Engineers comments in respect to surface water drainage:

APPLICATION NO: WA/75/17/PL

Site Address: Land adjacent to Sunny Corner Copse Lane Walberton BN18 0QH

Description of Works: 9 No. dwellings with associated car parking, bin storage & landscaping & creation of new access road from existing access onto West Walberton Lane. This application is a Departure from the Development Plan.

Appendix A Architects Layout GA

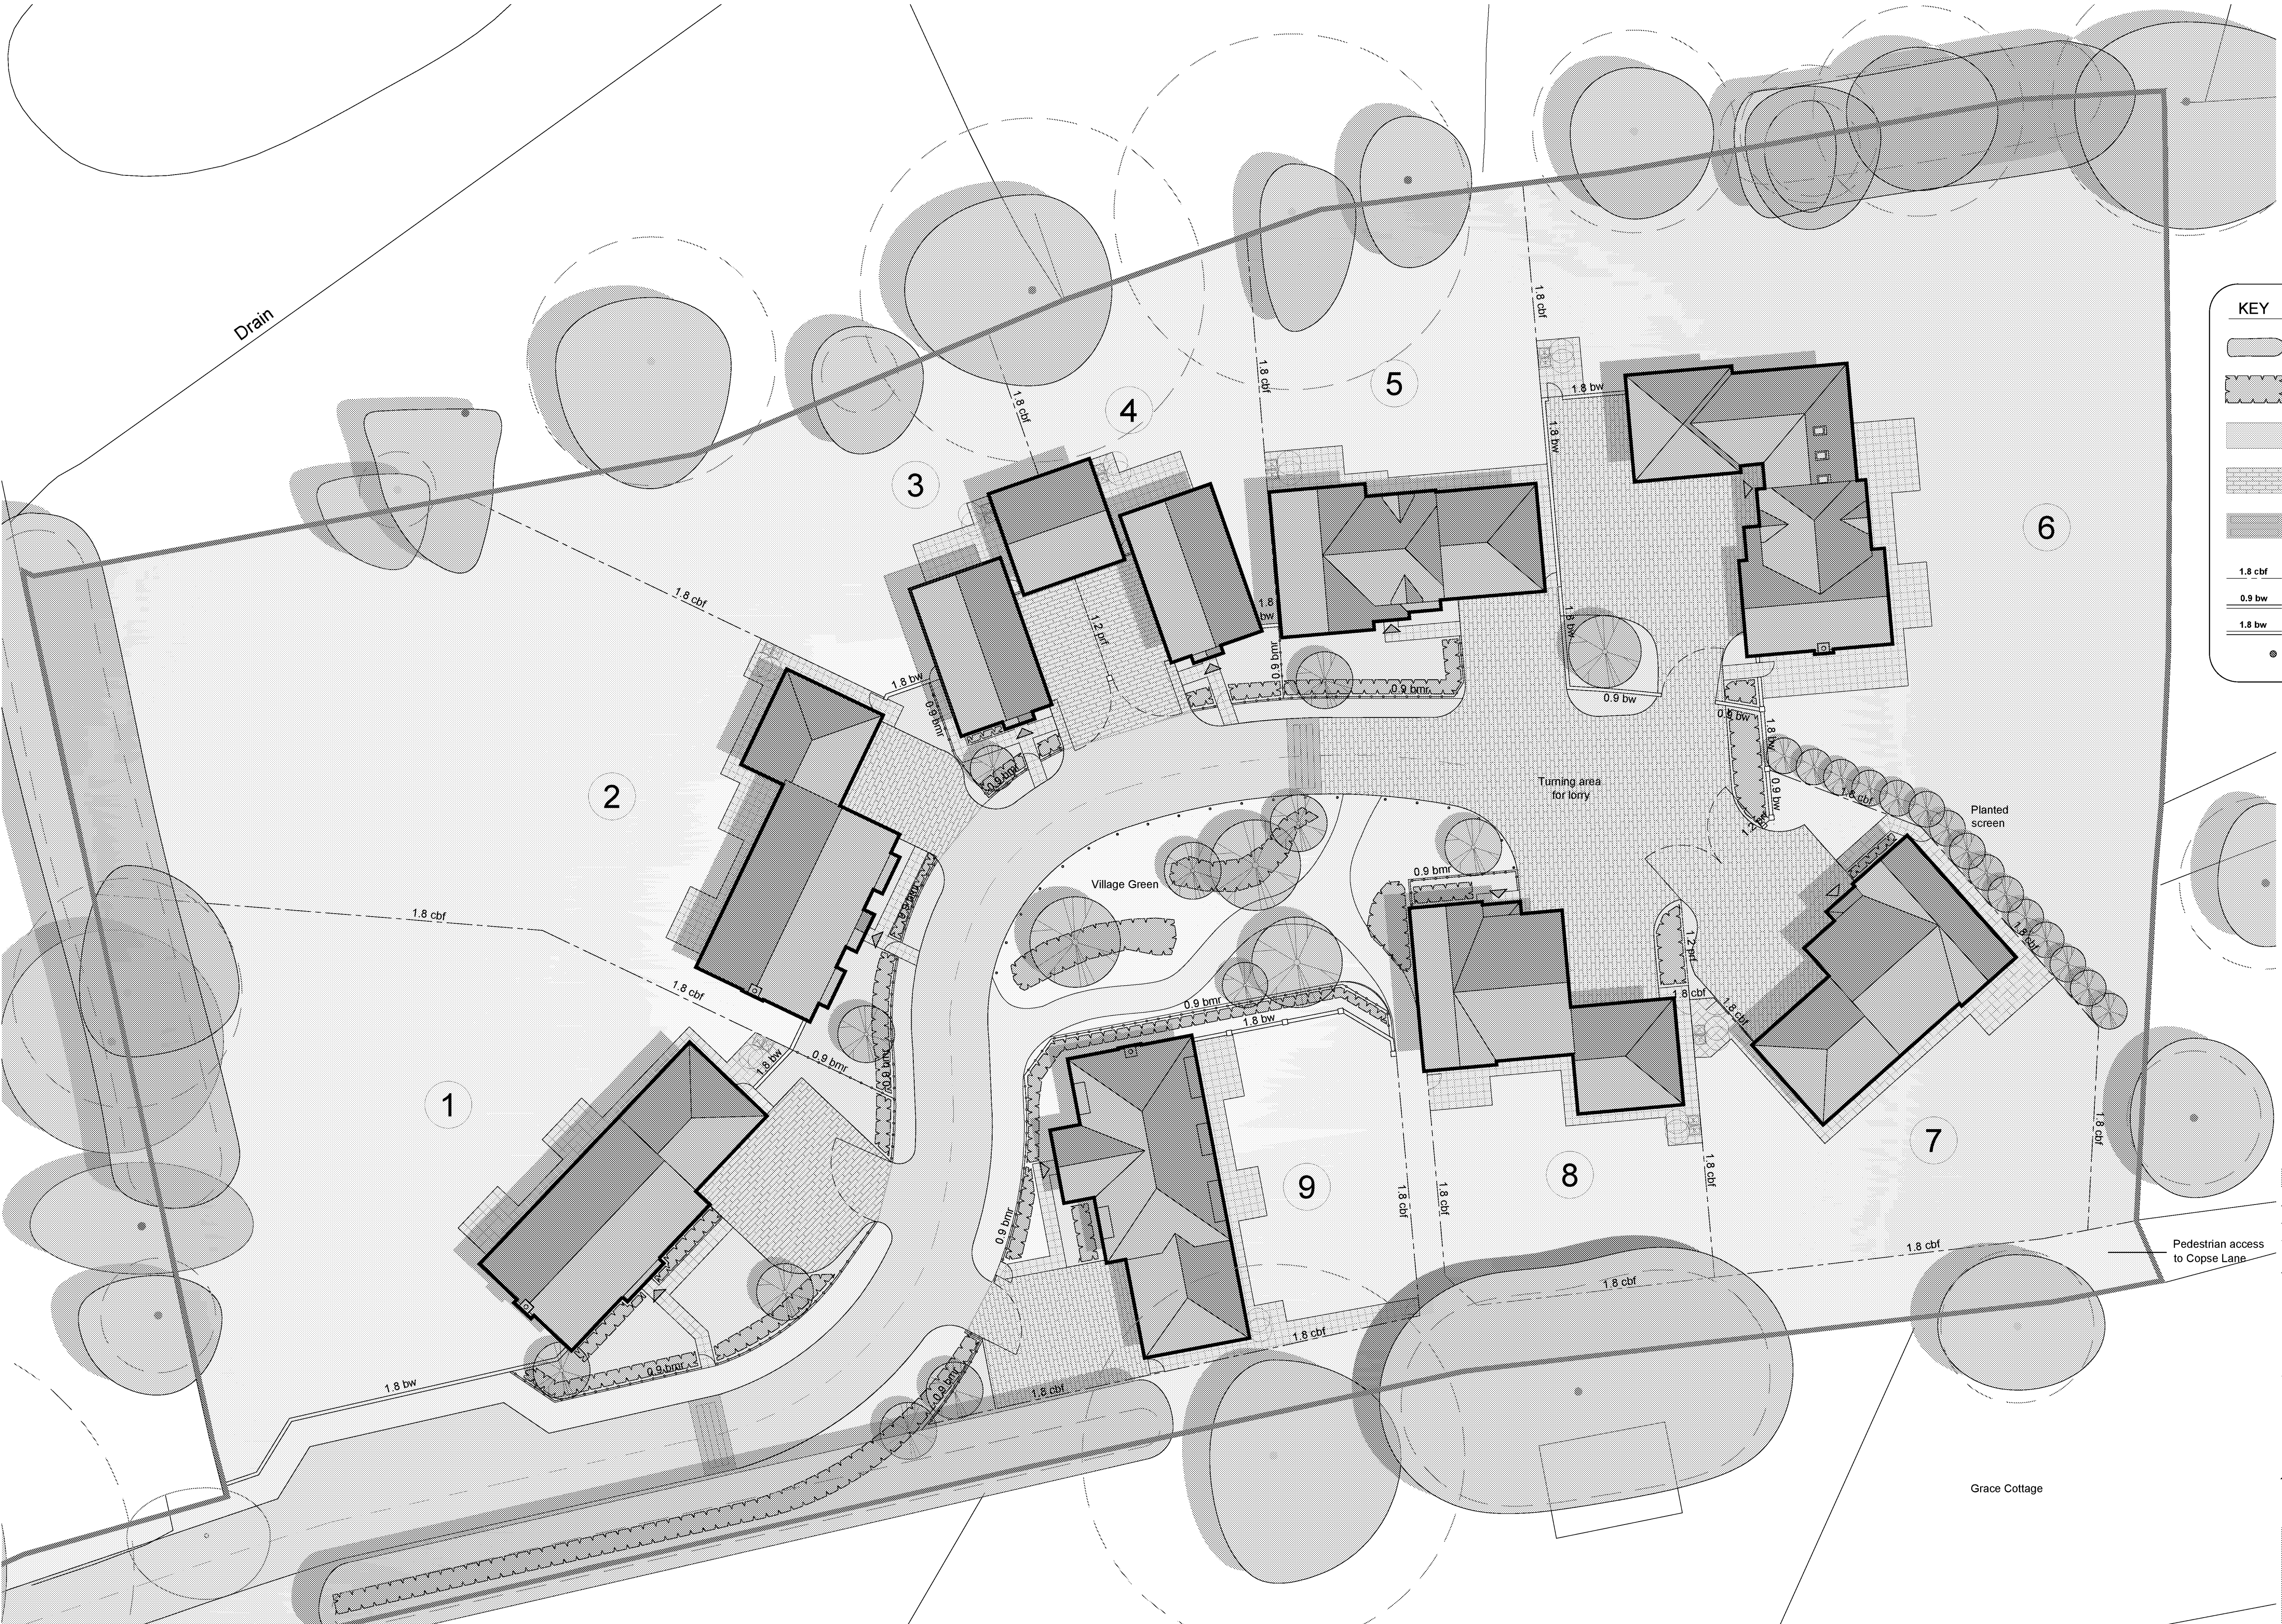
There is a watercourse on the western boundary. The proposed development layout does not fully consider future access for the maintenance of this ditch. The applicant will need to ensure that all boundary fences are kept at least 3 metres from the top of the ditch bank in order to provide a maintenance strip.
